Town and Country Planning Act 1990 (As amended)
Town and Country Planning (General Permitted development) Order 2015 Schedule 2 Part 1 Class A

Prior Notification for a Permitted Development (Householder)

Development: Notification under extended permitted development rights for a single storey extension to replace existing conservatory measuring 4.95m from beyond the rear wall of the original dwelling house, with maximum height of 3.70m and eaves height of 2.25m.

Location: 6 Bluebell Drive Littlehampton BN17 6UL

SIDE (e) ELEVATION 1:100 @ A3 / 1:50 @ A1

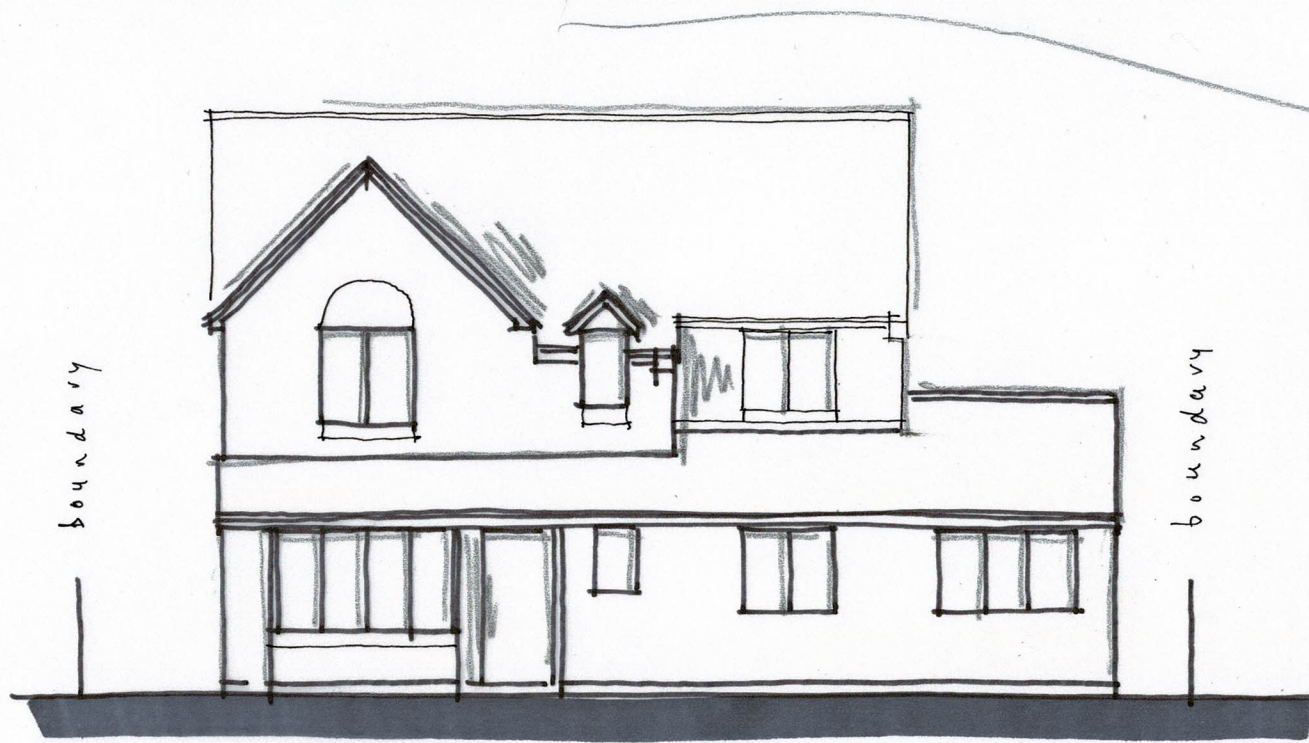
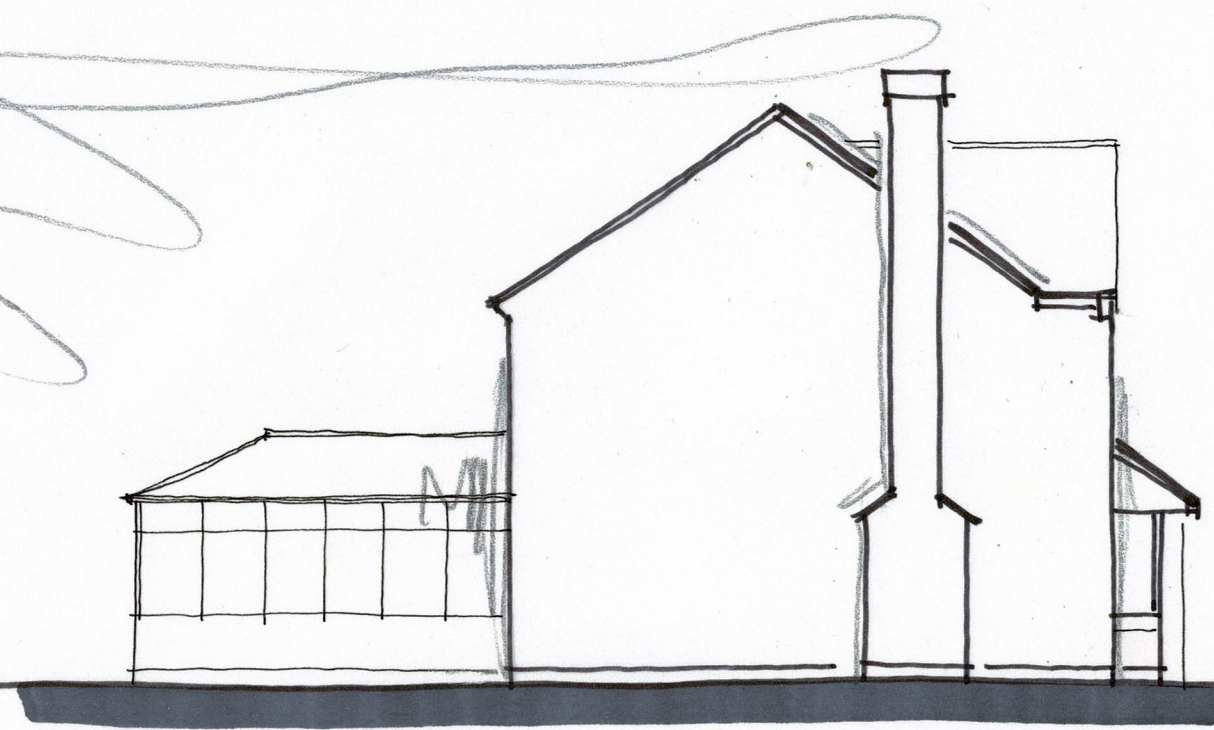
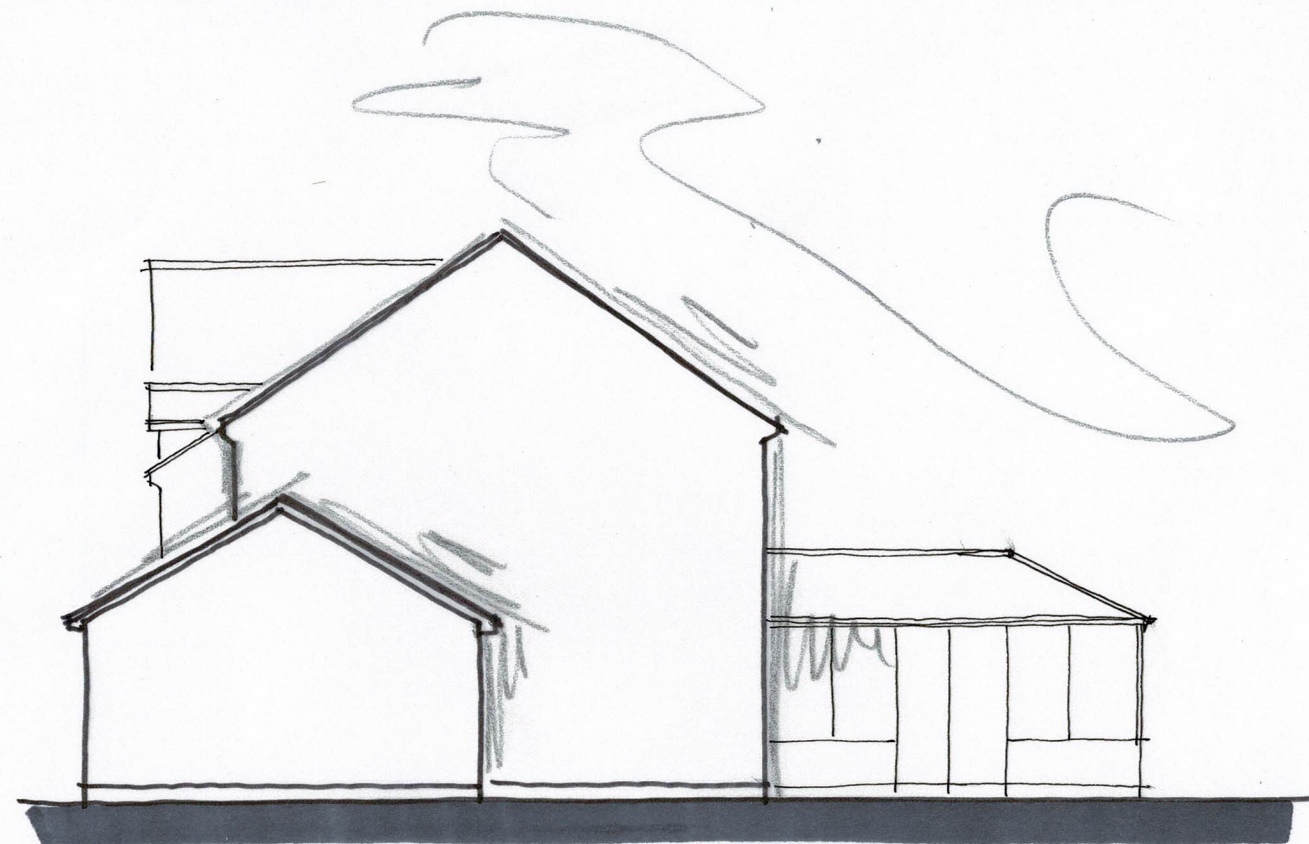
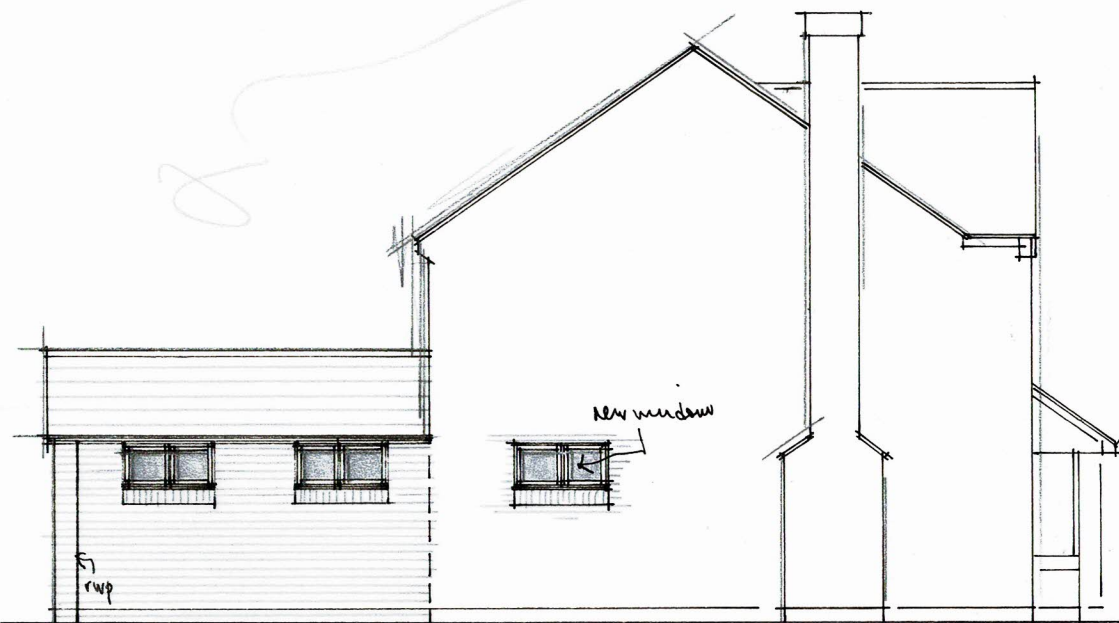
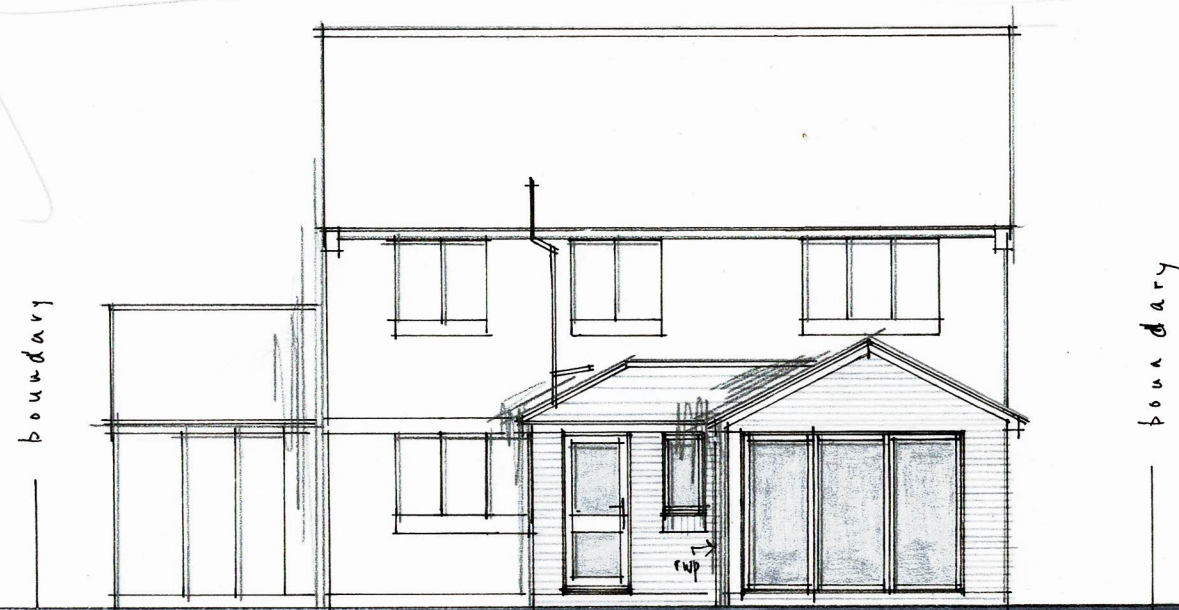
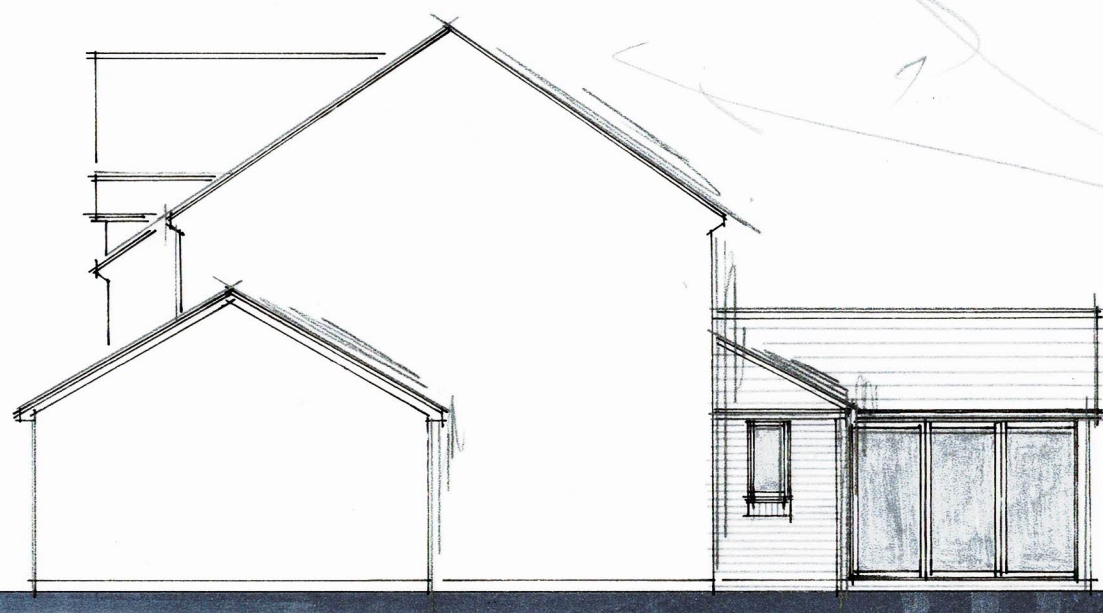
On the Proposed Ground Floor plan the kitchen window measures 1.7m, but on the Proposed Elevation measures 1.20m. Please check the measurements, amend accordingly and re submit.
